SUBMITTAL REVIEW COMMENTS

AE 0072-19 Mercer Island Transit Interchange

Submittal No./Ref./Title: 90% Submittal	Date Received: 9/18/2020
AHJ: City of Mercer Island	Date Due: [Due Date to Contractor]

DRAWING No.:  
**E07-CRY002**  
LOCATION ID:  
E07  
SHEET No.:  
9 OF 104  
REV:  
0

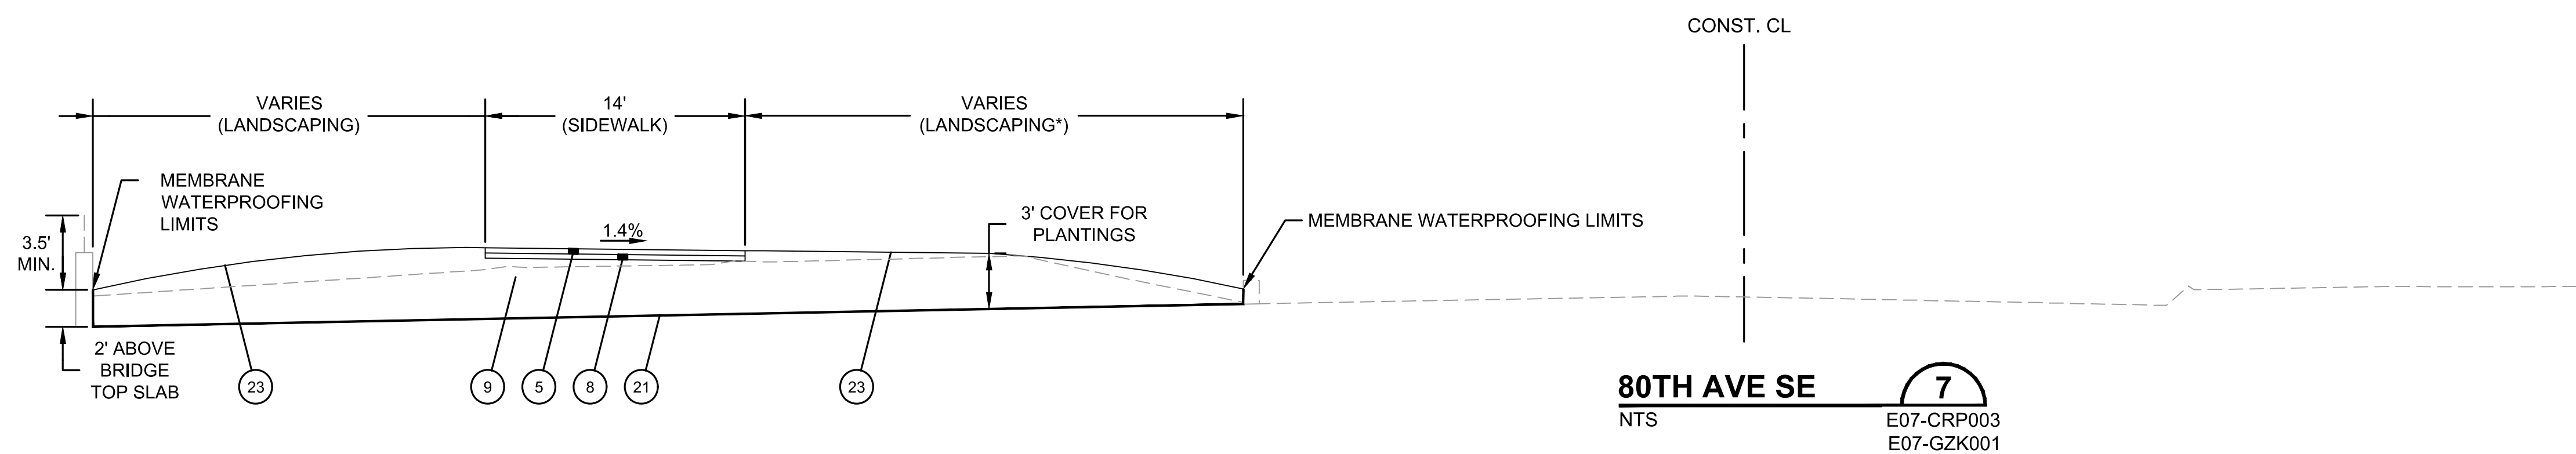
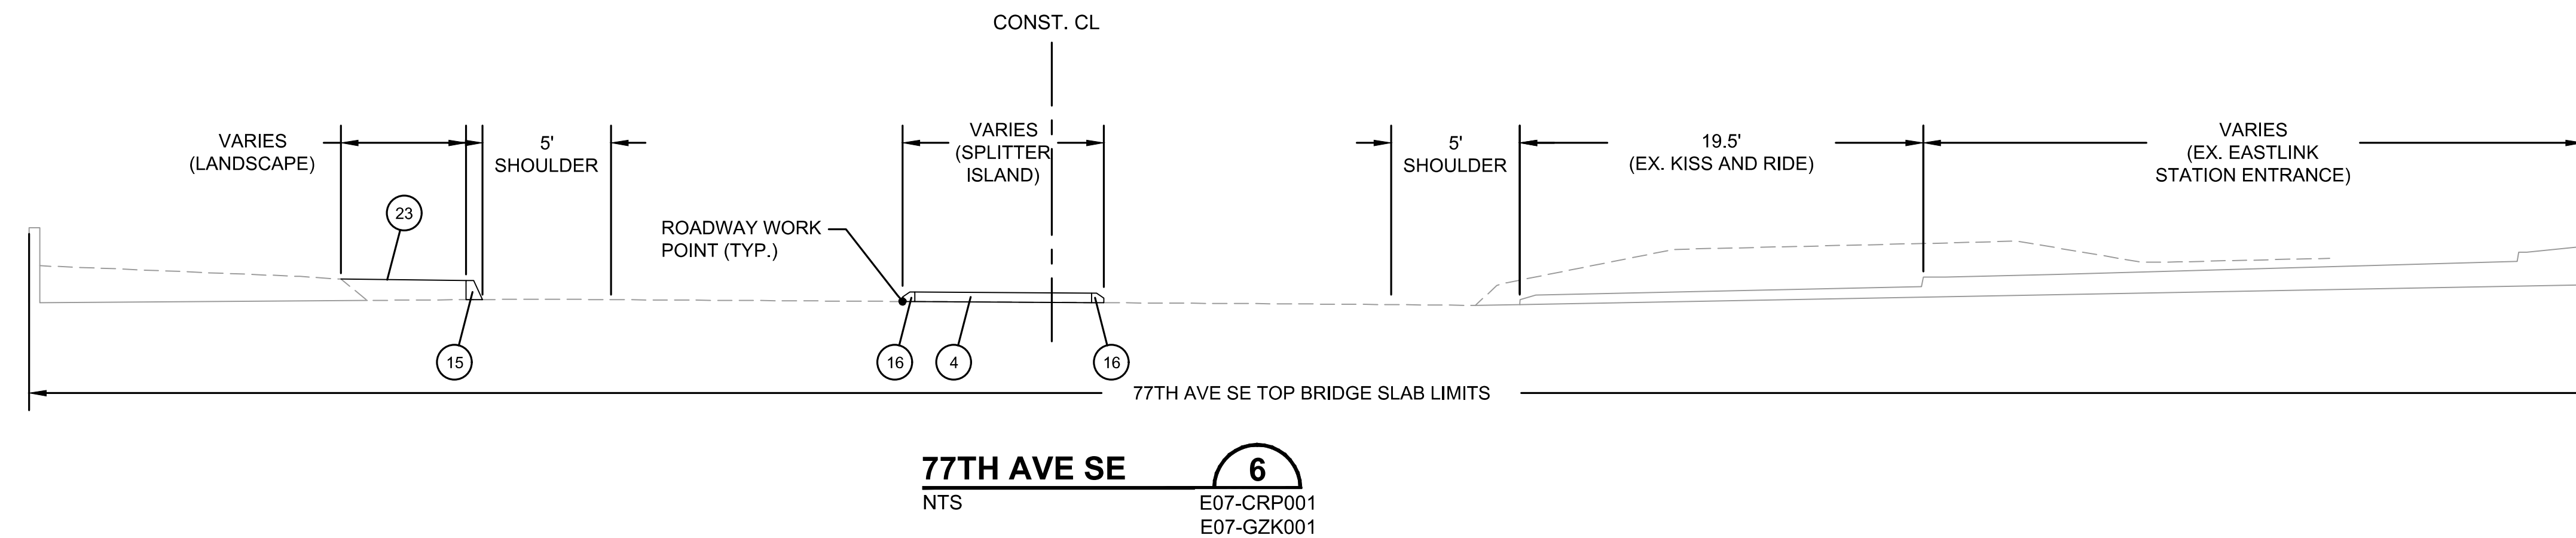
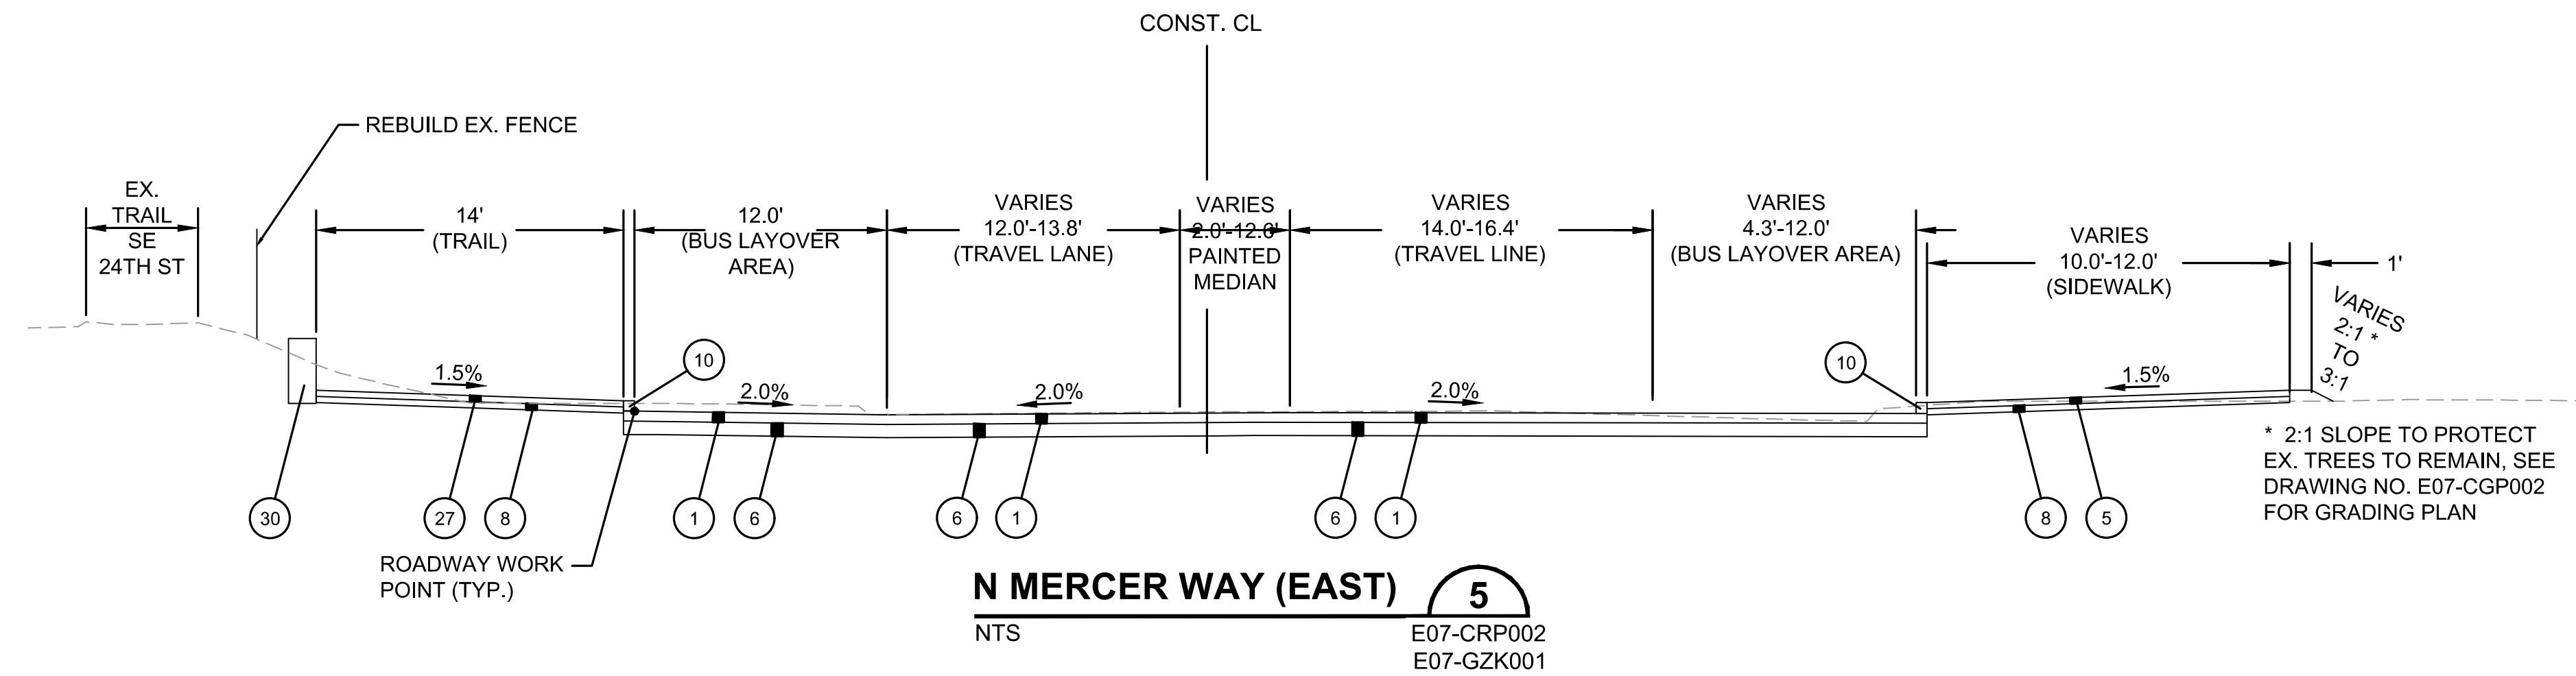
PW1	90% Plans	9/92 CRY002	TRF	60% - PW 5 comment has not been addressed in the 90% design. The plan views (e.g. CMP001) correctly shows the west side (southbound) bike lane on 77th Ave SE. Revise cross-section to be consistent with the plan view.	Will revise.	AD
PW2	90% Plans	12/96 CXP002	TRF	60% - PW 6 comment has not been addressed in the 90% design. Include in the site prep a note to remove the FH at approx. sta 11+52 north side. Since FH relocation is noted on utility plan, add note to Site Prep to relocate per UCP001.	Utilities are not within site prep/Demo plans. General note references UCP sheets for utility relocations, which include fire hydrant notes.	No Change
PW3	90% Plans	13/96 CXP003	TRF	Site prep note for 17 is missing or labels should be numbered 3.	Revised.	AD
PW4	90% Plans	15/96- 16/96 CTP001	TRF	60% - PW 9 comment has not been addressed in the 90% design. Add inlet protect for other CBs just outside the 'project limit' but potentially impacted by runoff. These include: <ul style="list-style-type: none"> • 80th Ave SE at 4+75 LT on east side. • 77th Ave SE within 'kiss-n-ride' • 77th Ave SE at 4+40 on west side near ramp. 	<ul style="list-style-type: none"> • Lid slopes towards west side on 80th so structure on east side is "uphill". • Do not see CB here- jbox? • Structure is in landscaped area outside of project limits – no need as no work in this planter area. 	AD

**EAST LINK EXTENSION  
MERCER ISLAND TRANSIT INTERCHANGE**  
77TH AVE SE, 80TH AVE SE, & N MERCER WAY  
ROADWAY AND PAVING PLAN

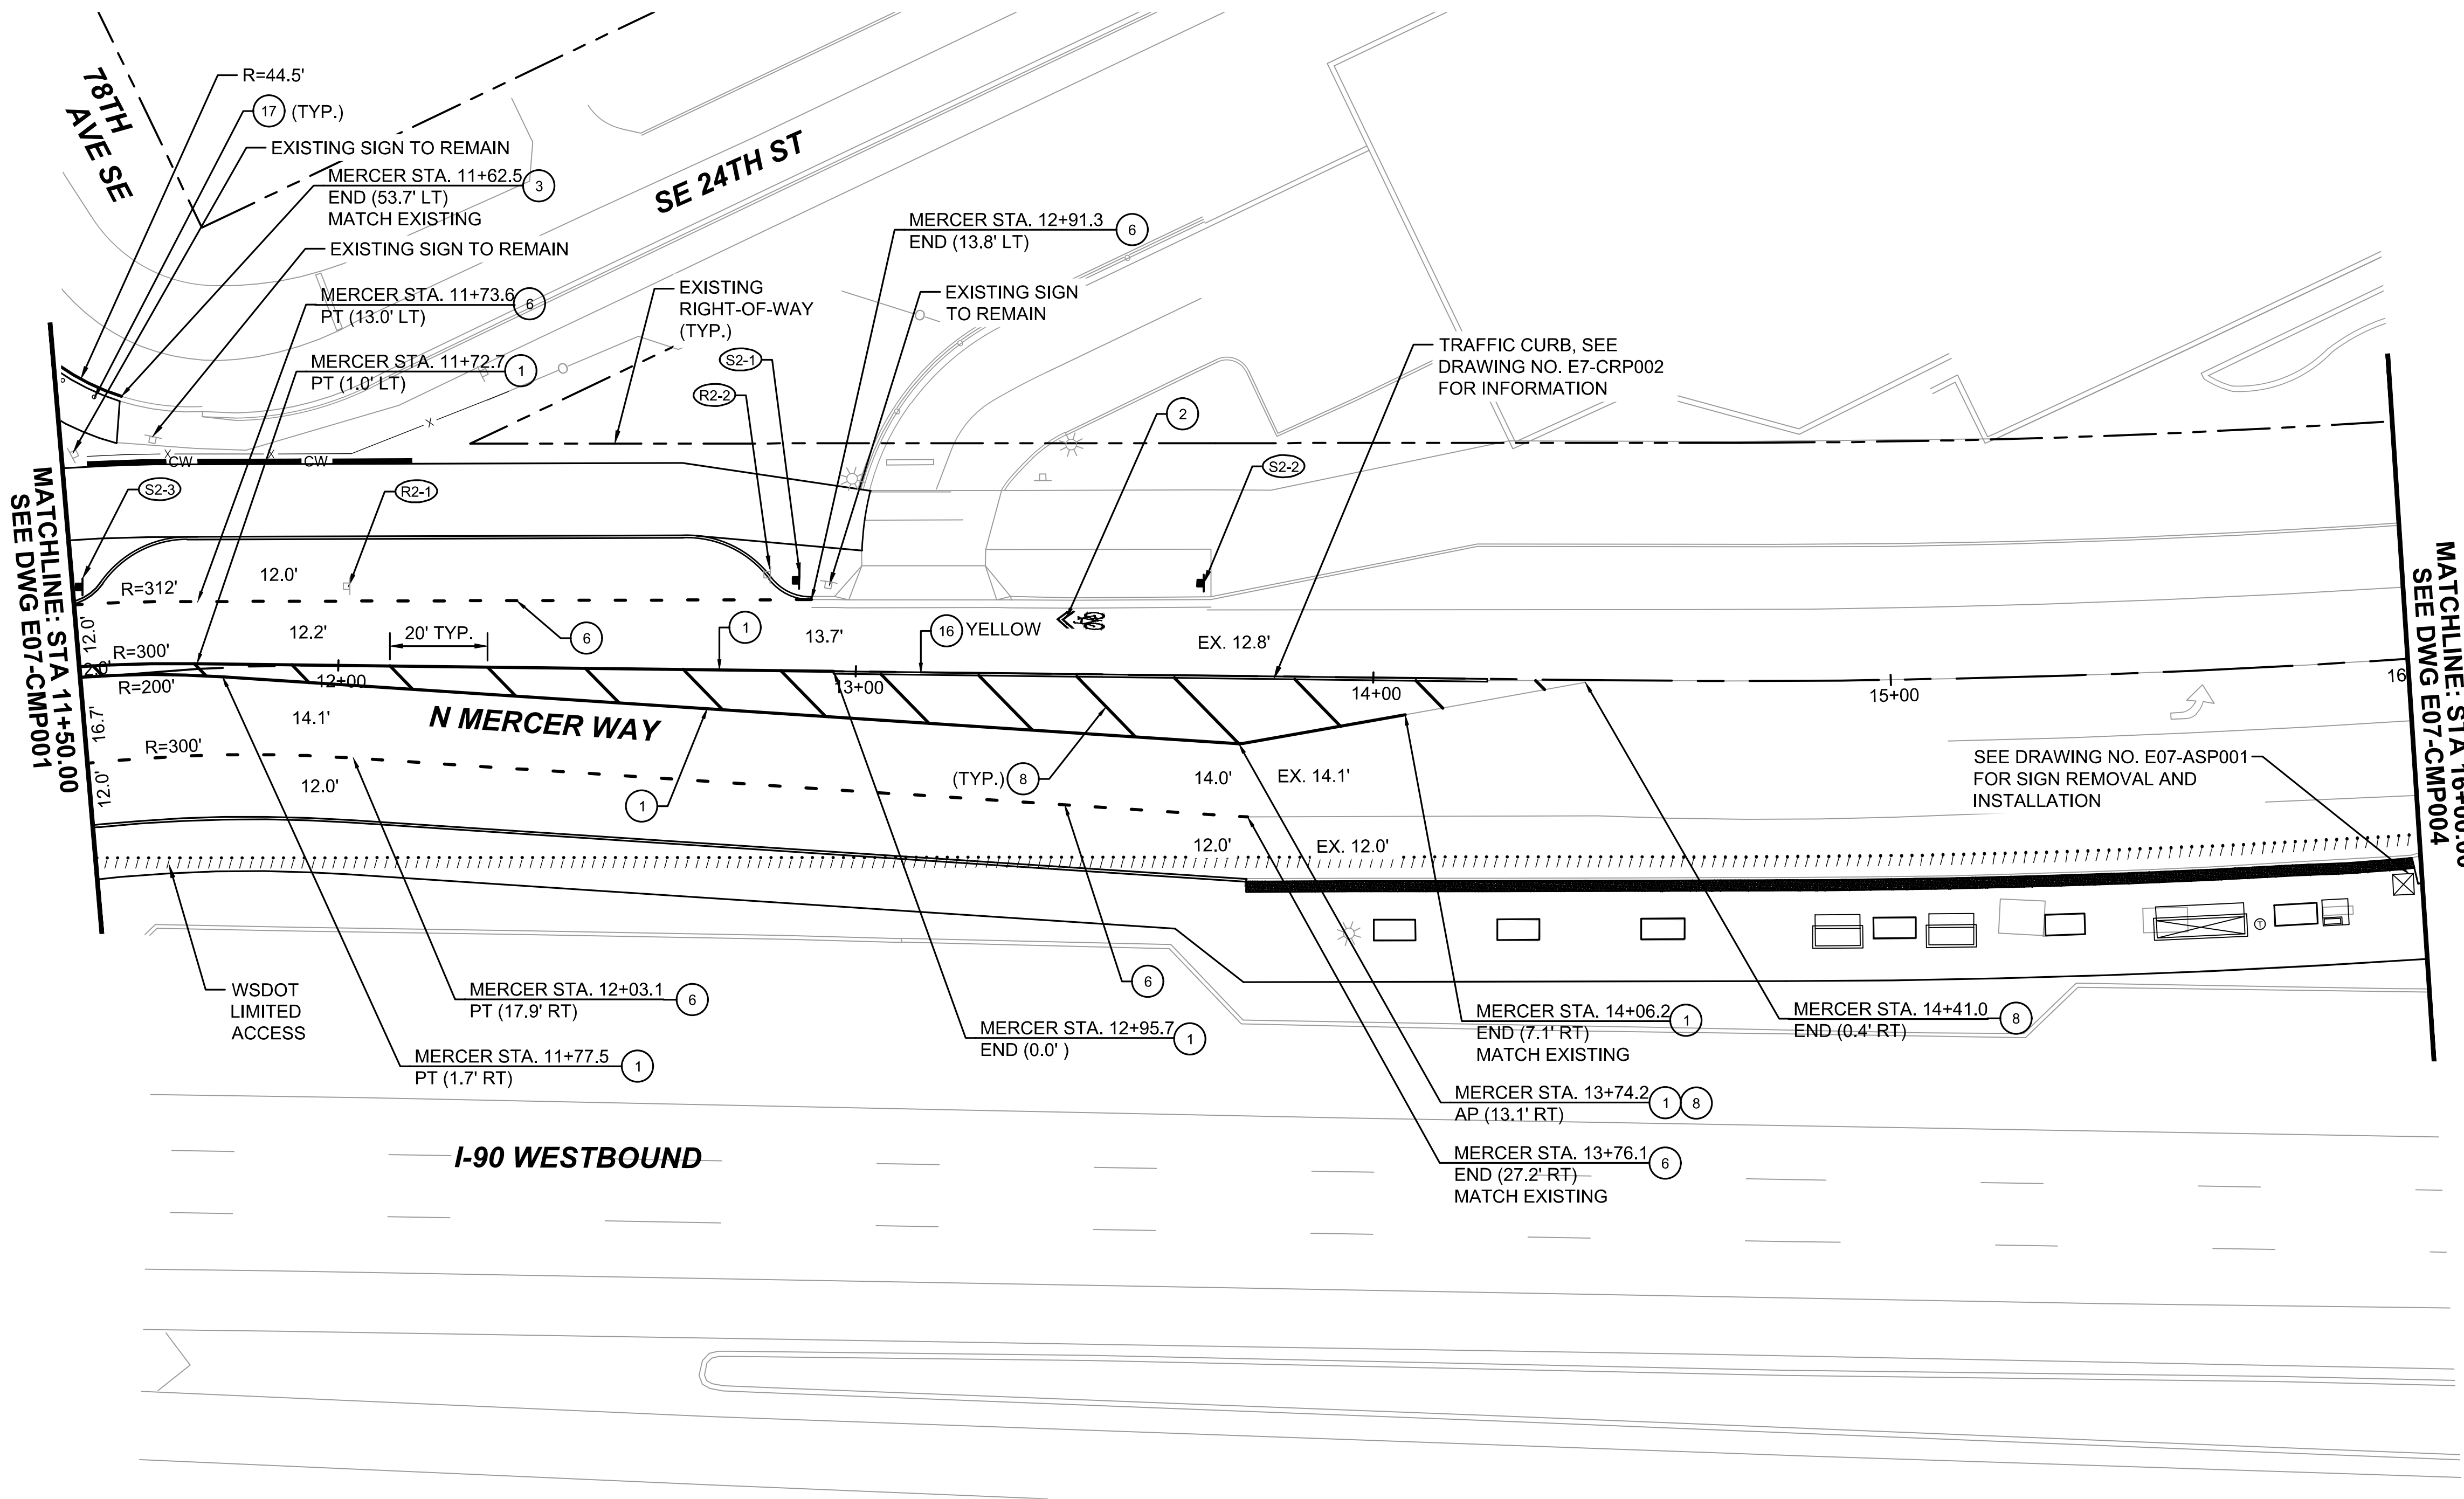
PW6	90% Plans	45/96 CMN00 2	TRF	Emergency/ST parking signage on 80th Ave SE. Revise signage from "No Parking" to "No Stopping or Parking".	Will review verify with 77th signage and ST signage	AD
PW7	90% Plans	46/96 CMP001	TRF	<p>60%- PW 10 comment has not been addressed by the 90% design or 60% response. The roundabout design is incomplete. It does not provide an adequate connection between the MTS Trail and the existing northbound and southbound bicycle lanes on 77th Ave SE.</p> <p>77th Ave SE is the primary north-south bicycle facility through downtown to the MTS Trail It is identified in both the City of Mercer Island's Comprehensive Plan and Pedestrian and Bicycle Facilities Plan.</p> <p>The current design directs NB bike lane users on 77th Avenue to enter the roundabout travel lane from which they cannot access the MTS trail without mounting a curb on the north side of North Mercer Way or making a "hard left" into the east leg crosswalk.</p> <p>Add a designated bicycle ramp for the NB bike lane to access the east leg crosswalk of the roundabout at the SW corner of the 77th Ave SE and N Mercer Way intersection. Include wayfinding signage and green thermoplastic to direct bicycles to the MTS Trail.</p> <p>For bicyclists to access the southbound bike facilities on 77th Ave NE from the MTS Trail, the design requires bicyclists to travel within the station entrance area, mixing with pedestrians and drop-off/pick-up activity. The design does not provide an adequate crossing of 77th Ave SE to access the southbound bike lane.</p>	<p>Please note that according to WSDOT there are not bike lanes on the LID, there is just a shoulder. Acknowledging the City's interest in this bike route on 10/7/20 we met with CMI to discussion the best solution for NB on 77th. We concluded at this point we should create a curb cut south of the kiss and ride area for bikes to access the shared path. Preliminary design for this solution is underway. This work is outside of the MITI project limits and can be completed outside of this project.</p> <p>For southbound cyclists on 77th, we will include signage as described in the CMI comment "Potential options could include providing wayfinding for eastbound MTS Trail users to direct them to use 76th Ave SE and the I-90 trail (south of I-90) to access downtown and the southbound bike lanes on 77th Ave SE" this can also be done outside the MITI project"</p>
